**DRAFT OBJECTION ON HERITAGE GROUNDS:
SSD 93020230 - 40-48 REDAN STREET, MOSMAN**

This letter has been commissioned by Chris and Rhae Shaw, the owners and occupiers of 73 Muston Street, Mosman in response to the State Significant Development Application ('SSDA') proposed at 40-48 Redan Street, Mosman. The proposal involves demolition of five dwellings, amalgamation of the residual six allotments, demolition of part of heritage-listed Redan Street and construction of an up to 10-storey building with additional two levels of basement car parking.

Figure 82 Basement 1 (21B1)

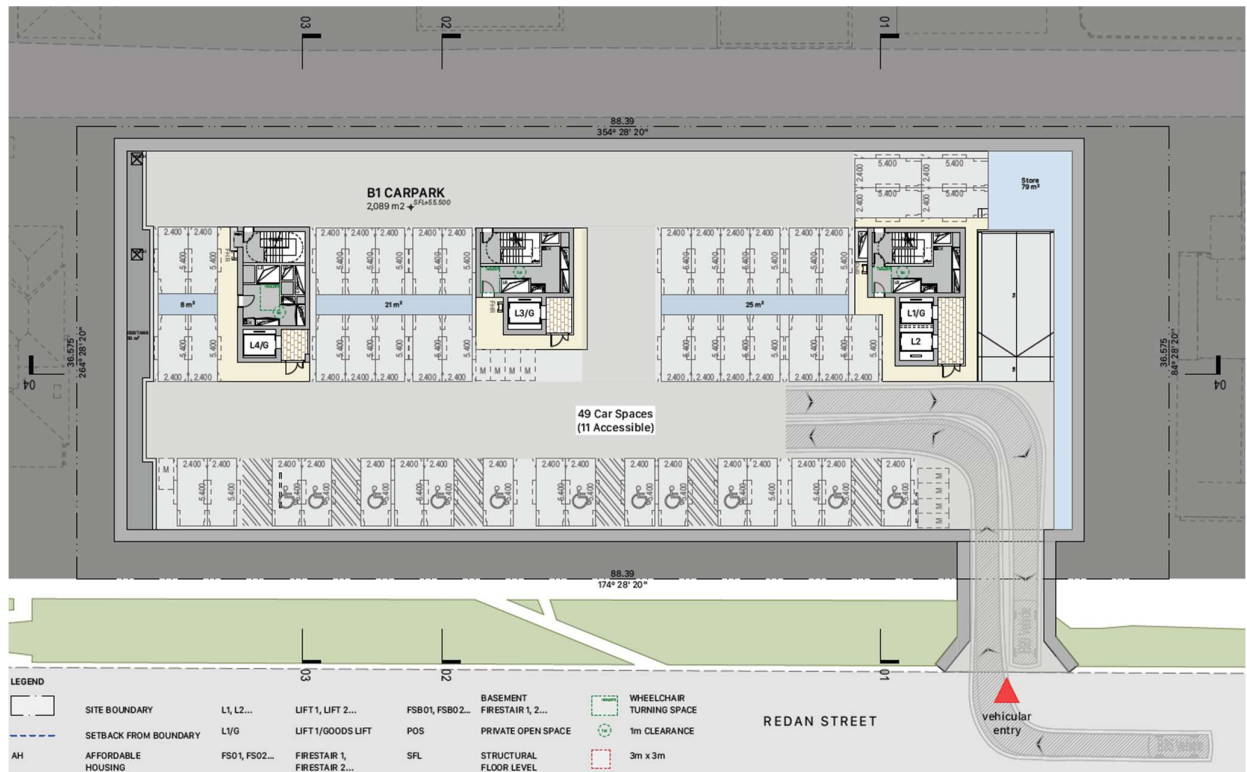
Contrary to MLEP, the proposal involves partial demolition of a heritage item on land adjacent to the Site to enable access to the basement carparking. Coupled with this destruction and fragmentation of the heritage item, the carpark opening is unequivocally inconsistent with the character of the western side of Redan Street, which does not include any driveway openings except for the rear of the property at 46 Almora Street.

Figure 96 Elevation East - Redan Street (3001)

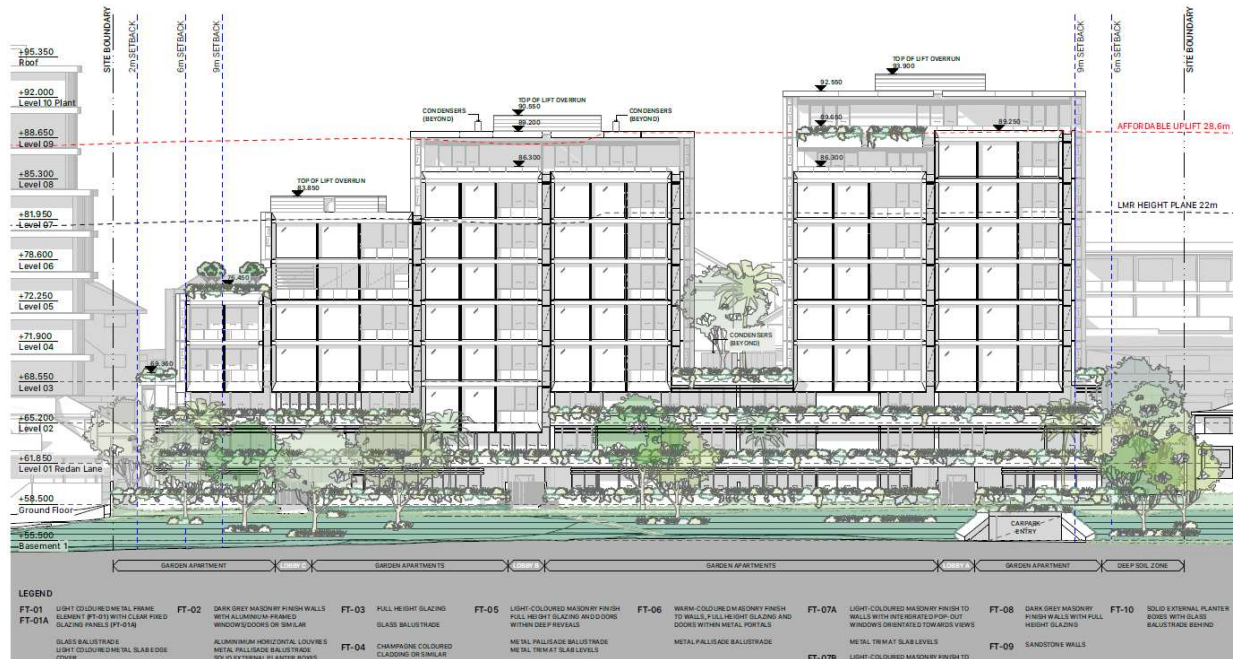
The proposed SSDA involves the construction of an up to 10 storey residential flat building adjacent to the heritage item. Whilst the built form incorporates some stepping in its form on the southern side, this is tokenistic, and the resulting building pays no regard to the scale and grain of the existing heritage item. Moreover, there is no clear streetscape analysis provided to demonstrate how the new building responds to its heritage context, i.e. the adjacent heritage item. Instead, the streetscape elevation provides a (non-existent) building to the south which masks the scale of the adjacent heritage item.

The ADG outlines heritage as a factor that should influence the building height of new residential apartments. However, the proposed building is excessively large not only in the context of the adjacent and nearby heritage item but also when considering Redan Street, which is specifically heritage-listed for its embankment presentation, landscape features and response to the sloping topography.

Irrespective of how the proposal is viewed, it does not respond to the height of the adjacent and nearby heritage items. Moreover, the steeply sloping topography requires greater rigour to be applied when considering a new building's height.
